**OBJECTION**

**State Significant Development Application No: SSD-10300**  
**Coffs Harbour Cultural and Civic Space**

SOUTH ELEVATION

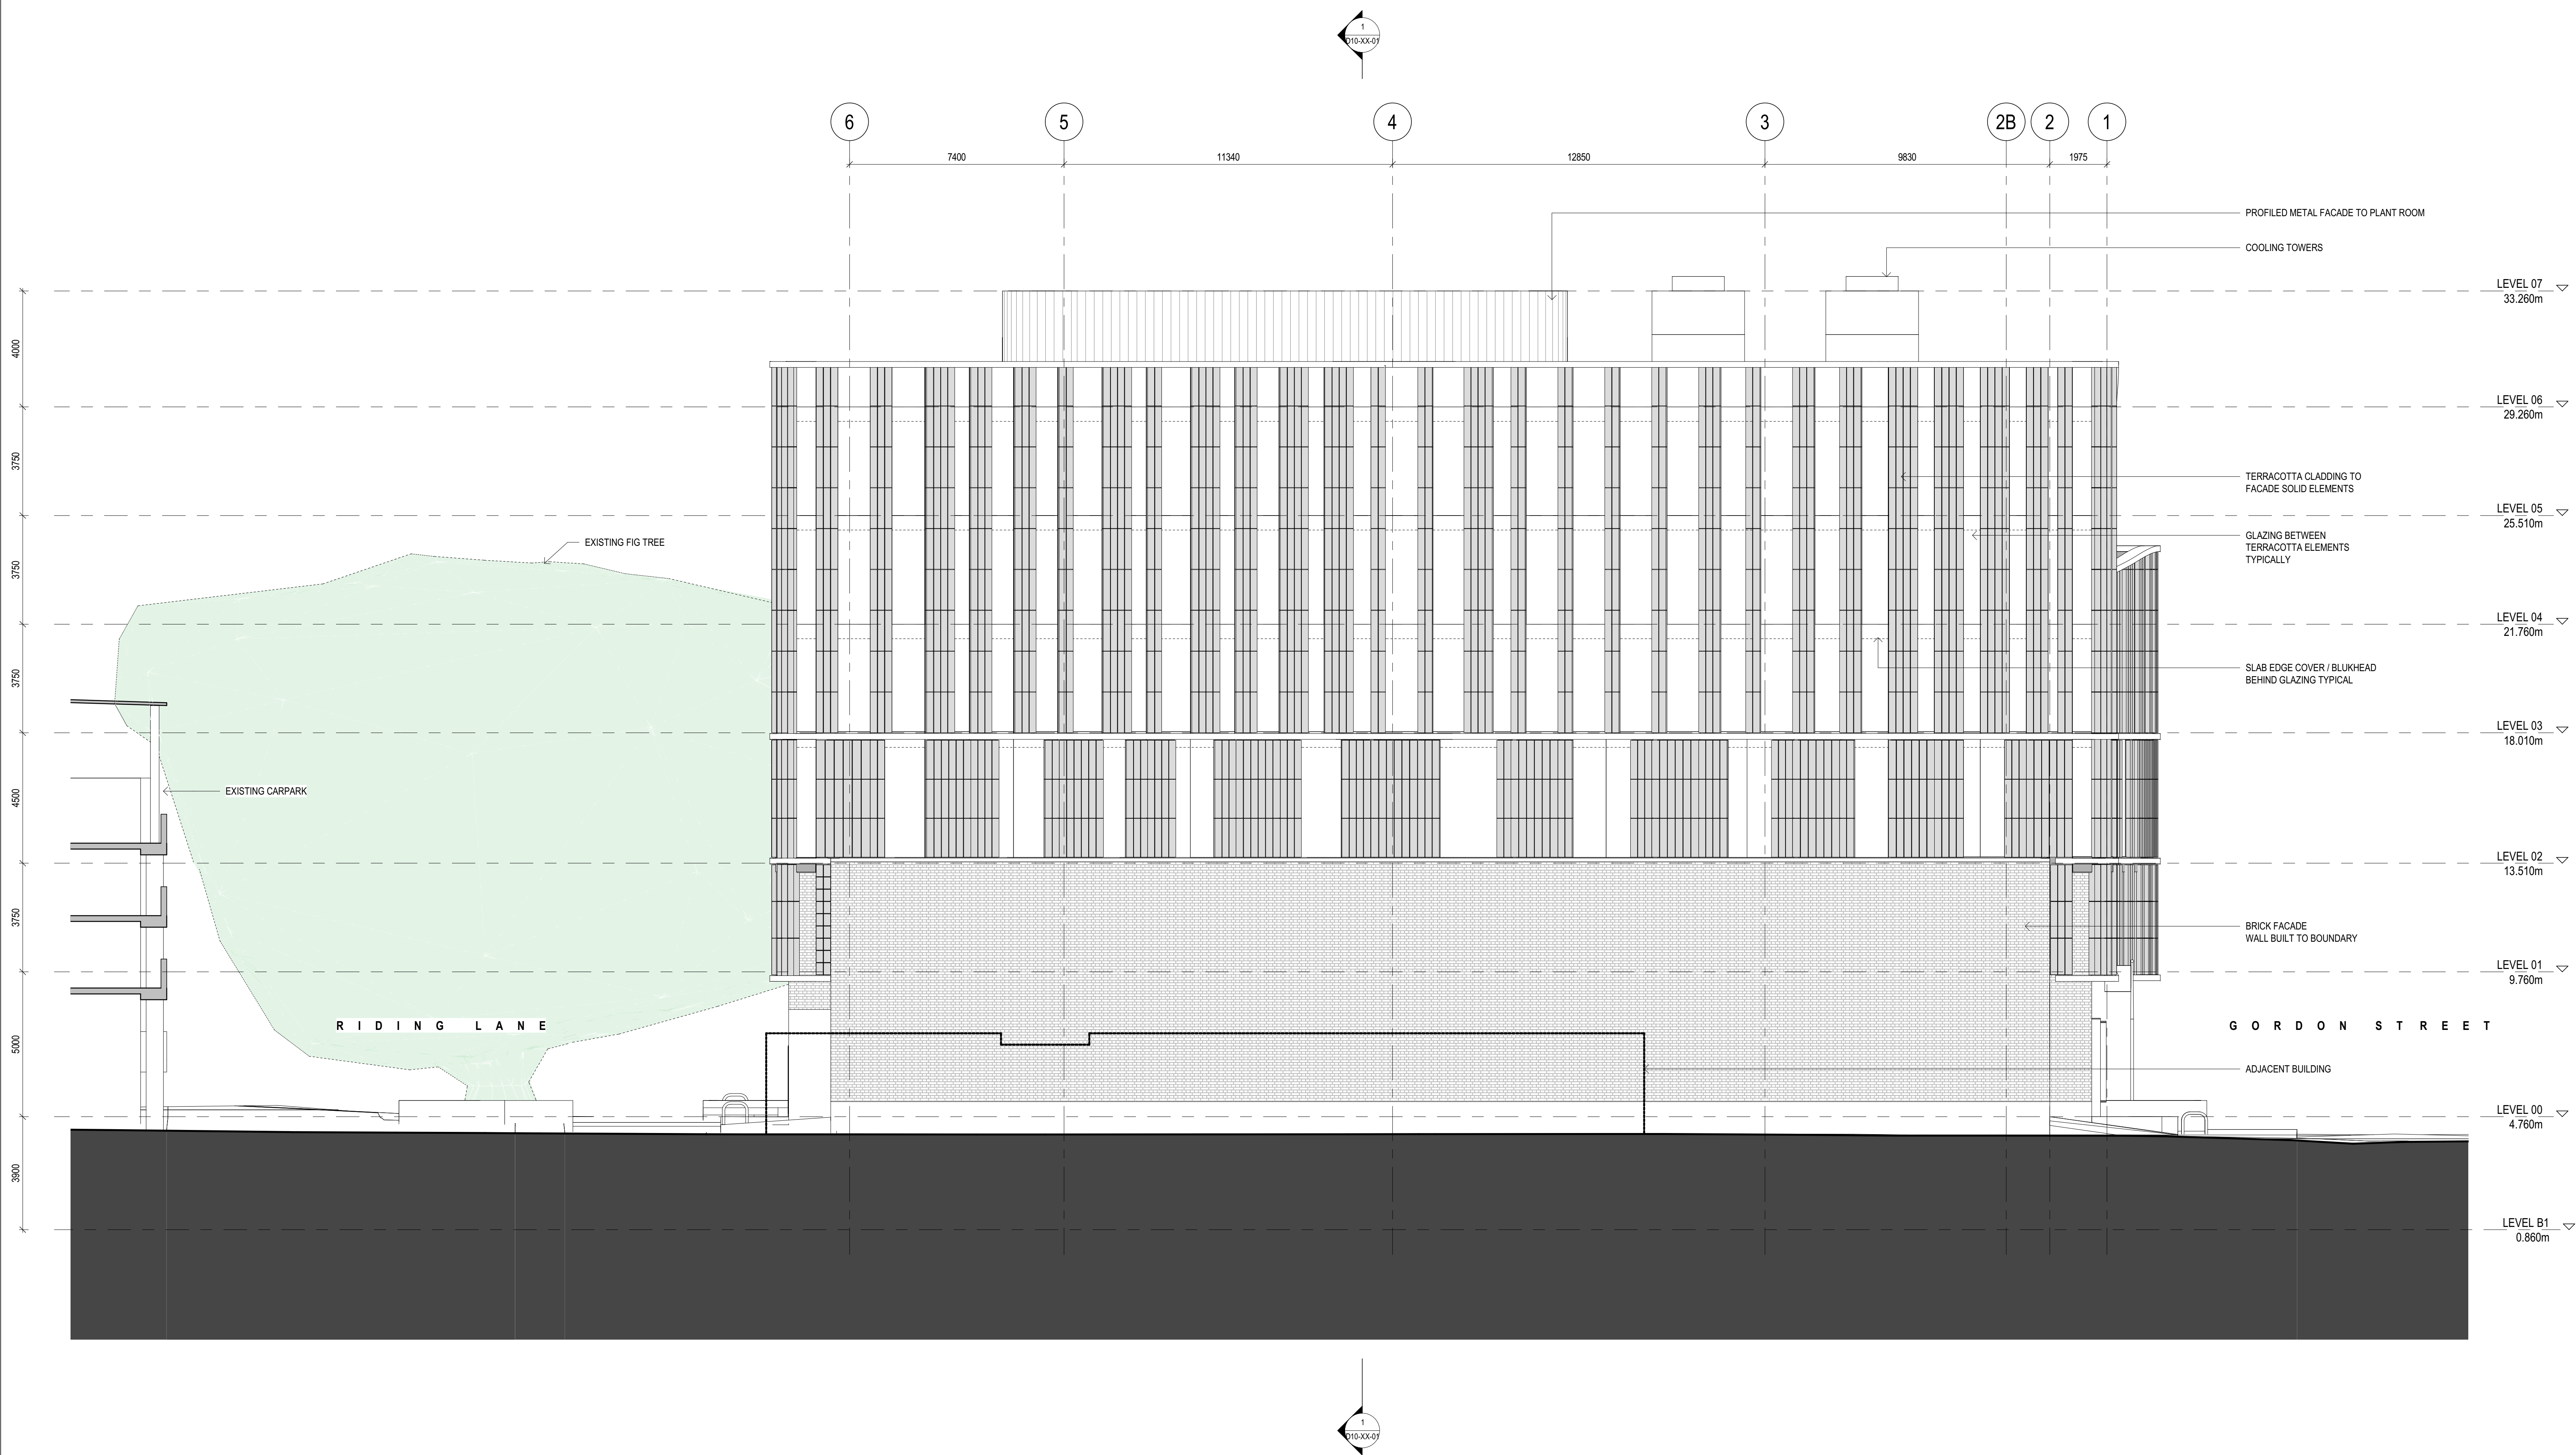
5. The proposed building is out of context in the street with no regard to scale, existing street setbacks, design and general form of adjoining buildings.

RIDING LANE ELEVATION

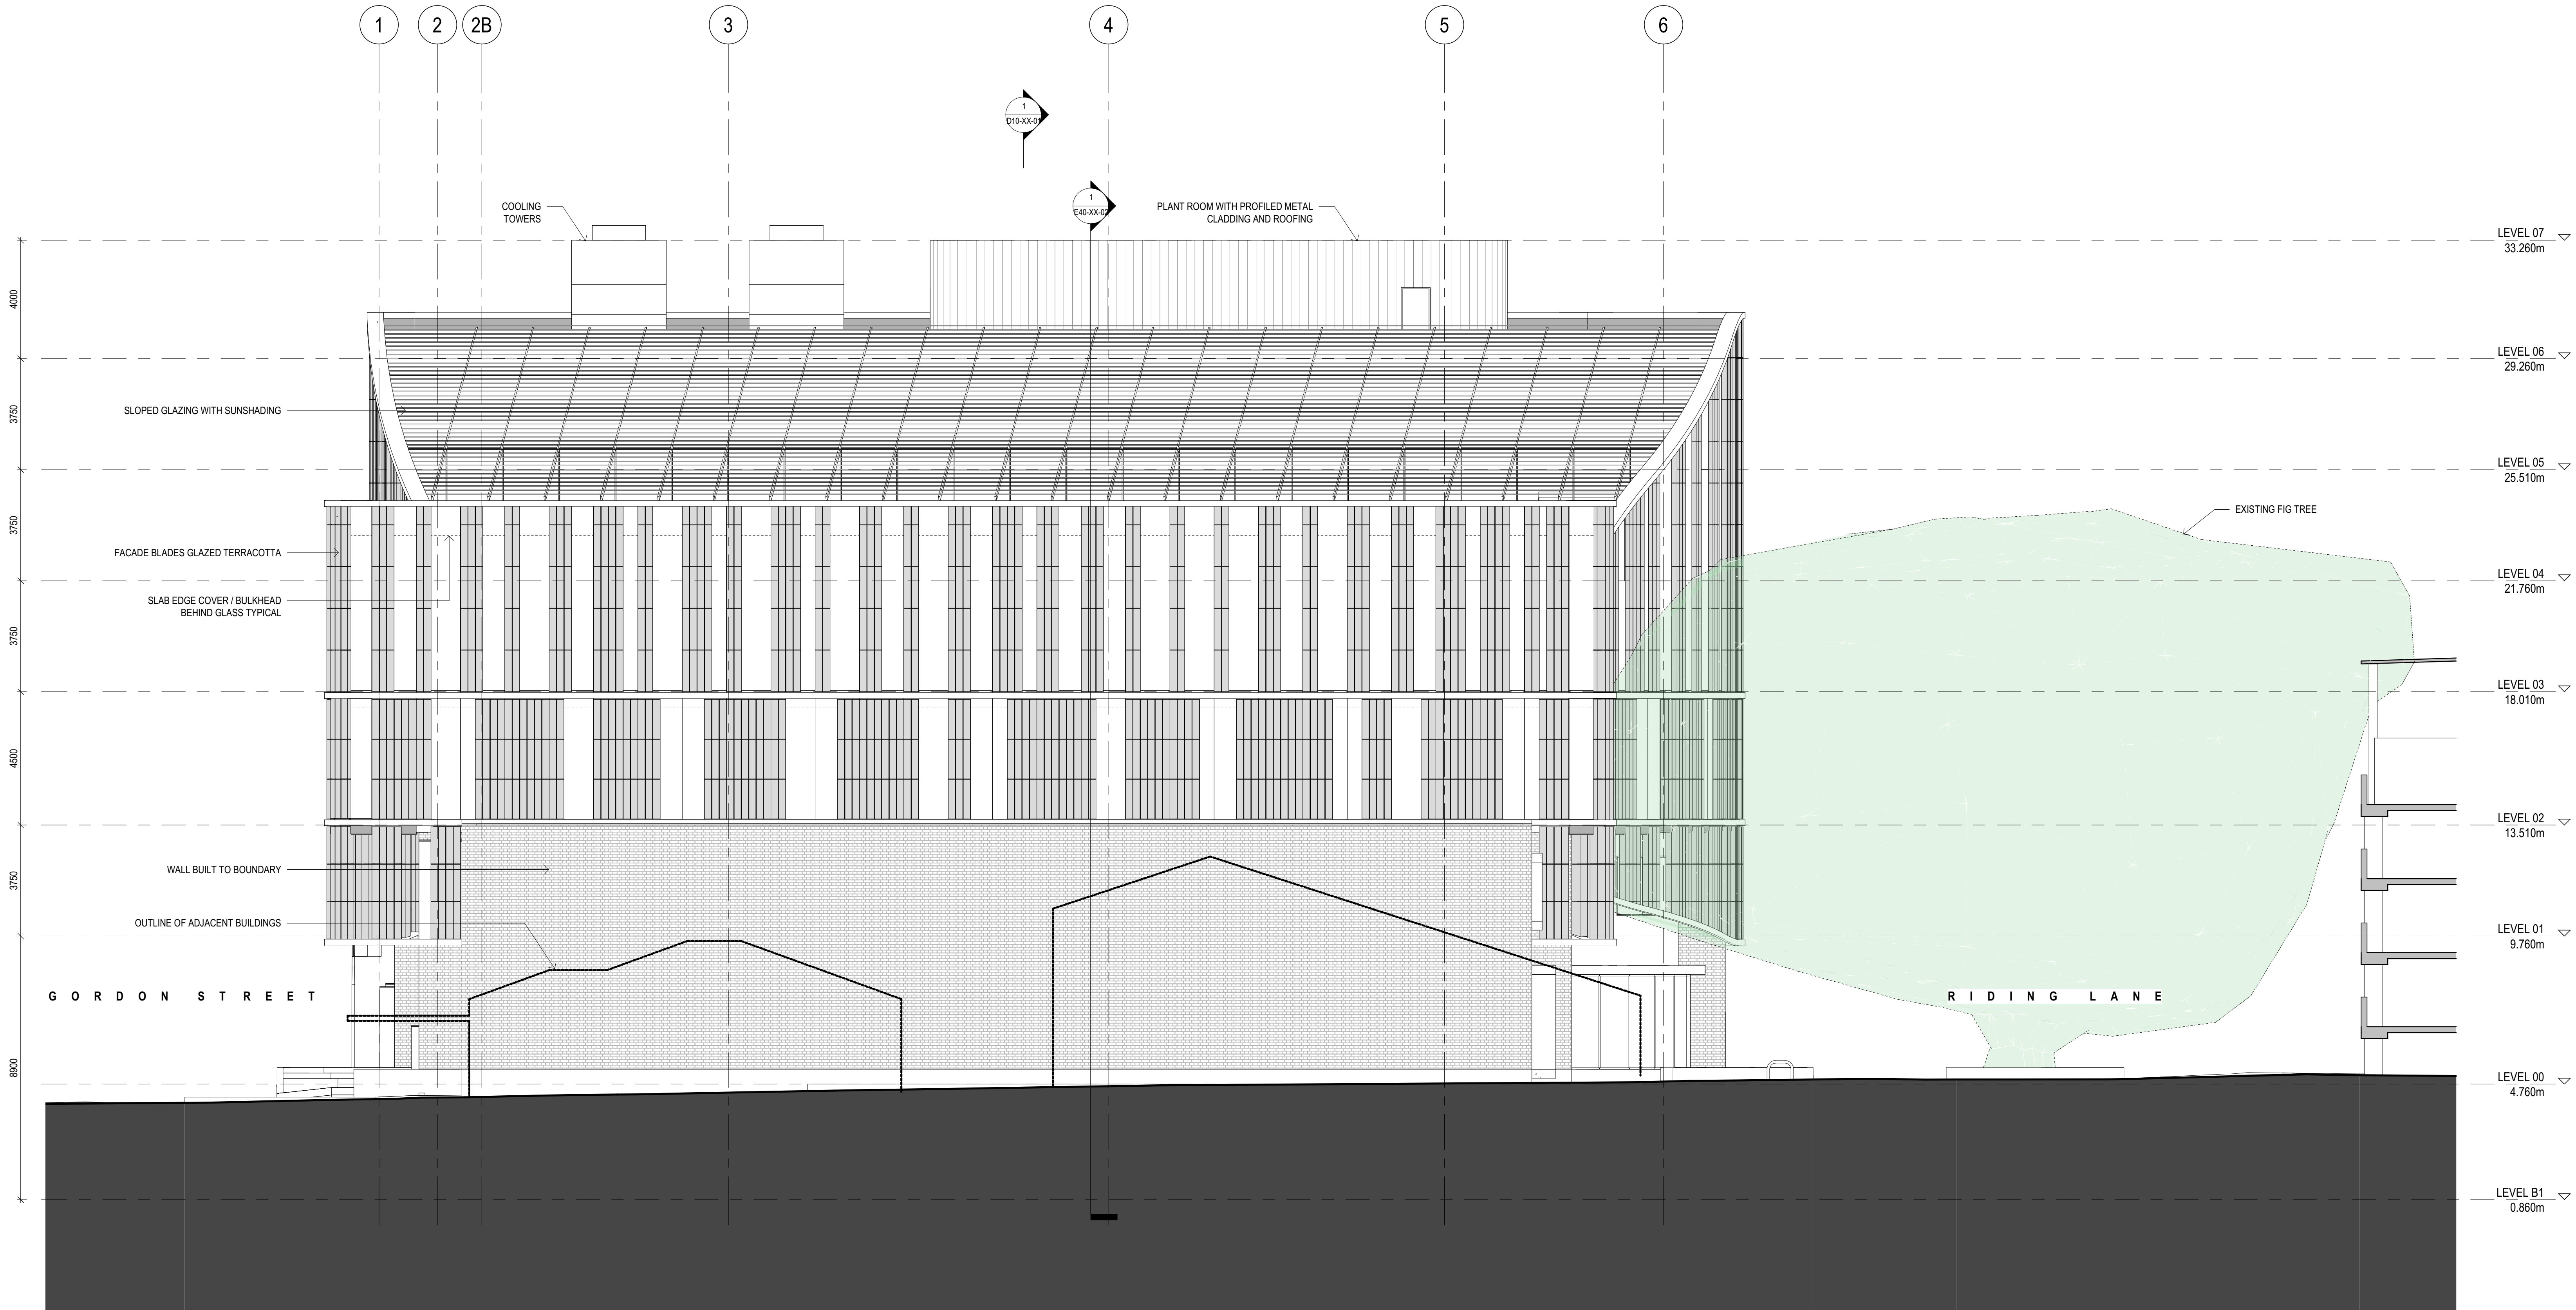
6. The proposal does not meet "safer by design" principles and guidelines, as the arcade to Riding Lane confuses boundaries and provides "hides" for criminal activity, vagrancy and prevents good surveillance.

SECTION N-S

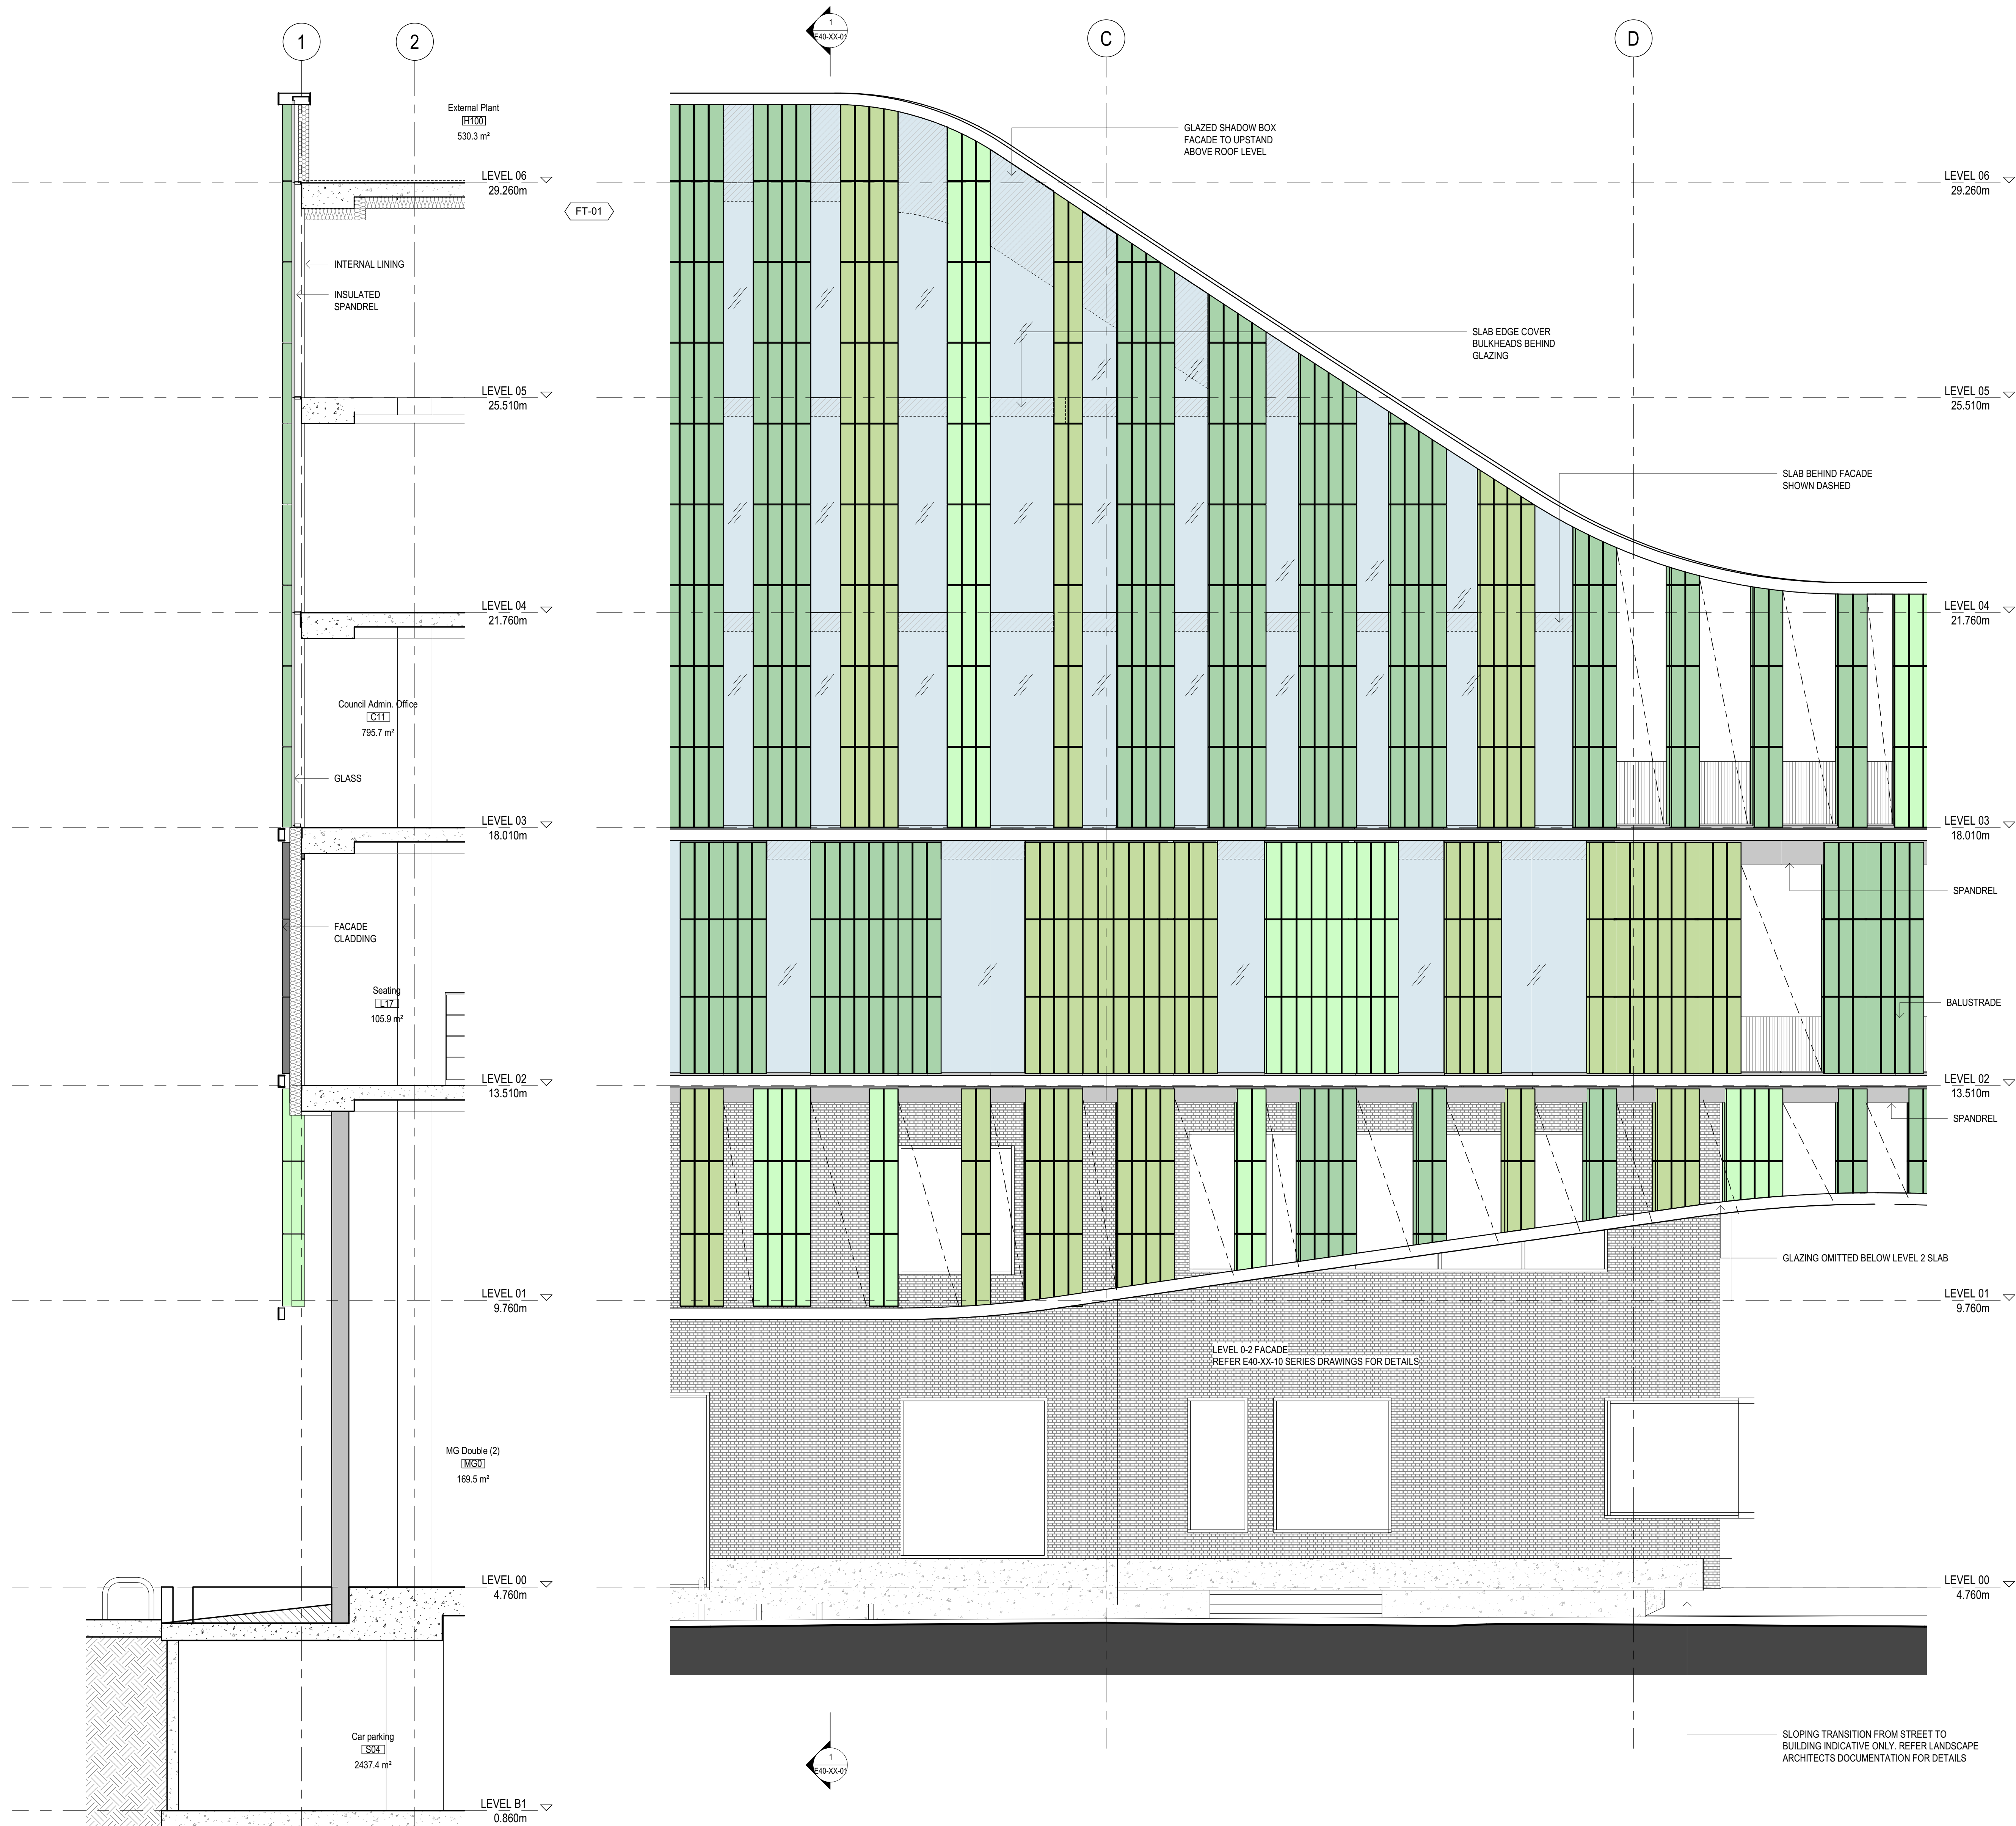
7. As a public building it fails to provide sufficient climate protection for pedestrians during storms and summer sun.
8. The building exceeds the height restriction of 28m set down in Council's own planning controls. Council's argument for variation is not satisfactorily justified and is not consistent with the objectives of the Environmental Planning and Assessment Act 1979, which requires the "the orderly and economic use and development of land". Council should not receive preferential treatment.
